**BCA Assessment Report**  
**Metcash State Distribution Centre**  
**Bungarribee Industrial Estate**  
**Huntingwood NSW**

3 September 2010

Revision 1

TITLE SITE PLAN - STAGE 5

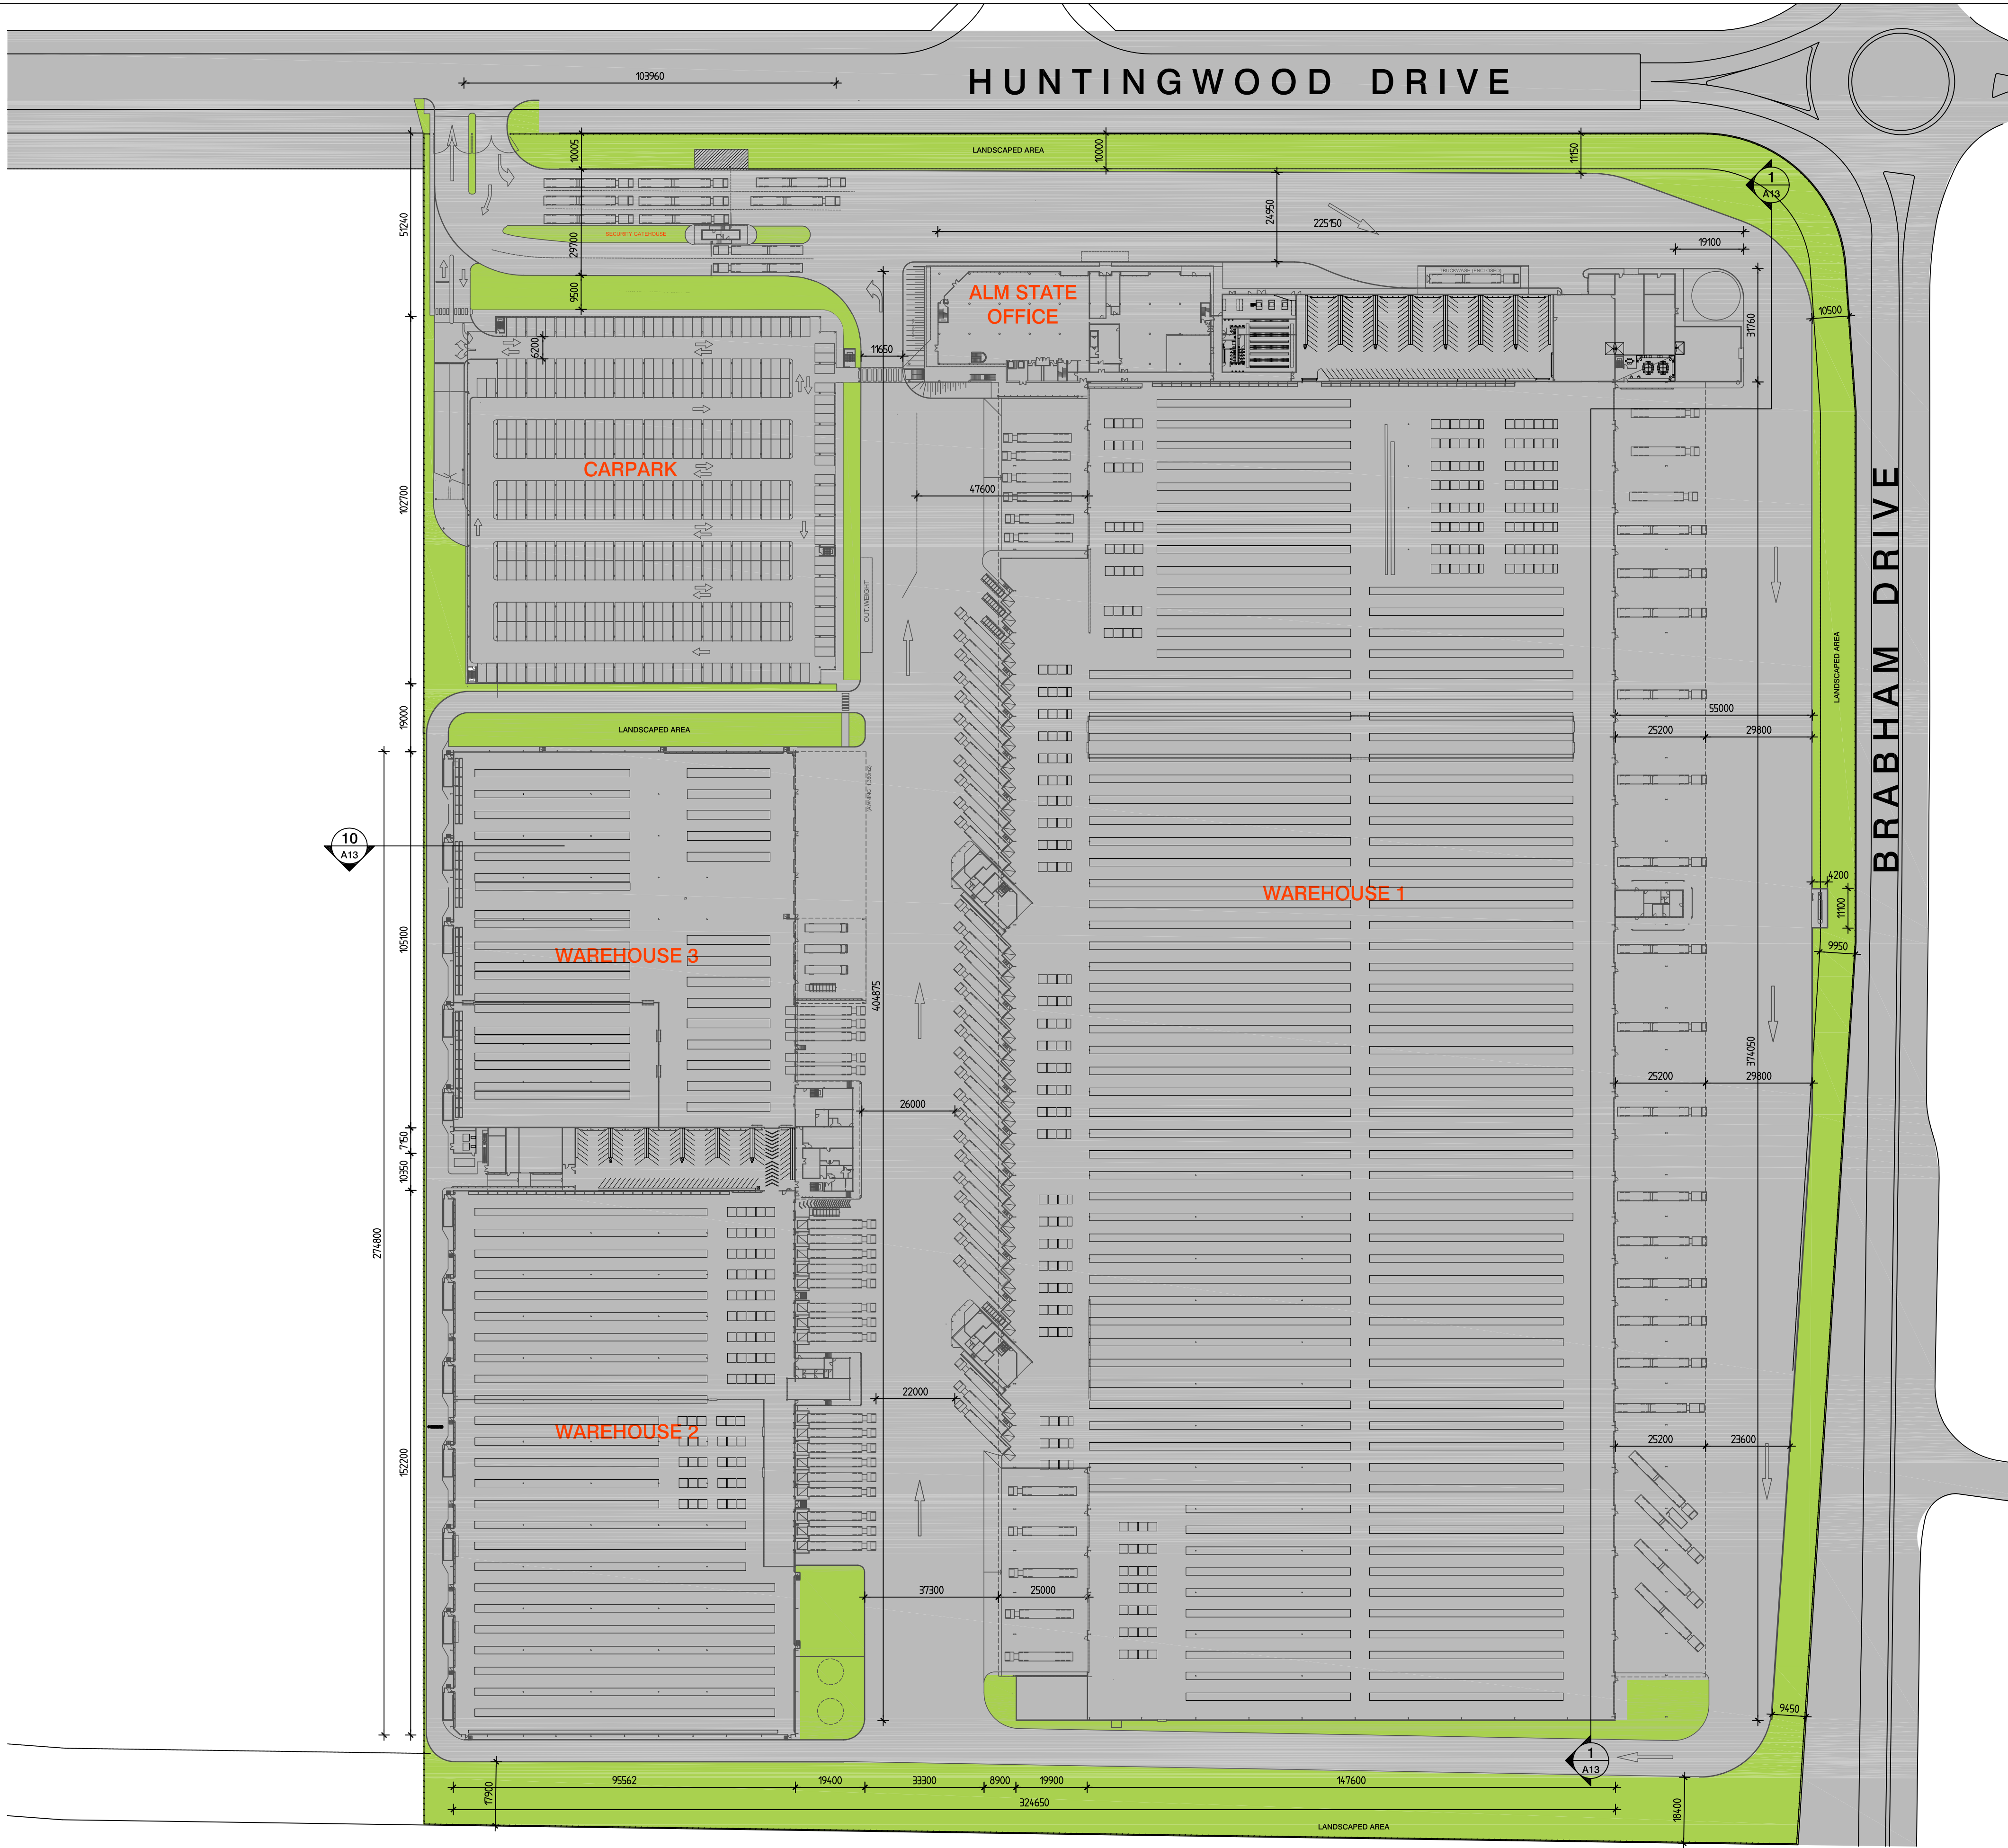
- a) Vehicular access at the south-eastern corner of Building 2 (Stage 5) is provided via the adjoining driveway to the east of the building, however as the driveway is greater than 18m from the eastern external wall it's setback is non-compliant with the requirements of C2.4.

- b) Temporary access roads will be required along the southern end of Building 1 for both Stages 1 and 2, along with the southern end of Building 2 for Stage 2 and the northern end of Building 3 for Stage 2. As the future stages of these buildings are constructed the temporary access roads will need to be removed to facilitate the building works and hence for a period of time each of the buildings will not be provided with perimeter access to one side. Therefore, during the various construction phases the perimeter access to both Building 1 and Buildings 2 & 3 will be non-compliant for a period of time as follows: (i) during the construction phase of Stage 3 (Building 1 non-compliant – southern end) and (ii) construction phase of Stage 5 (Building 1 – southern end and Building 2/3 – southern and northern ends will be non-compliant).

- c) Perimeter Vehicular Access will be provided in the north-west corner of Building 1 will pass directly under the pedestrian bridge connecting the carpark building to the main office entry. The provision of this bridge over the vehicular accessway is not compliant with the requirements of C2.4(a)(iv).

It will be necessary for an alternative solution to be prepared to address these non-compliance issues, in order to demonstrate compliance with Performance Requirement CP9.
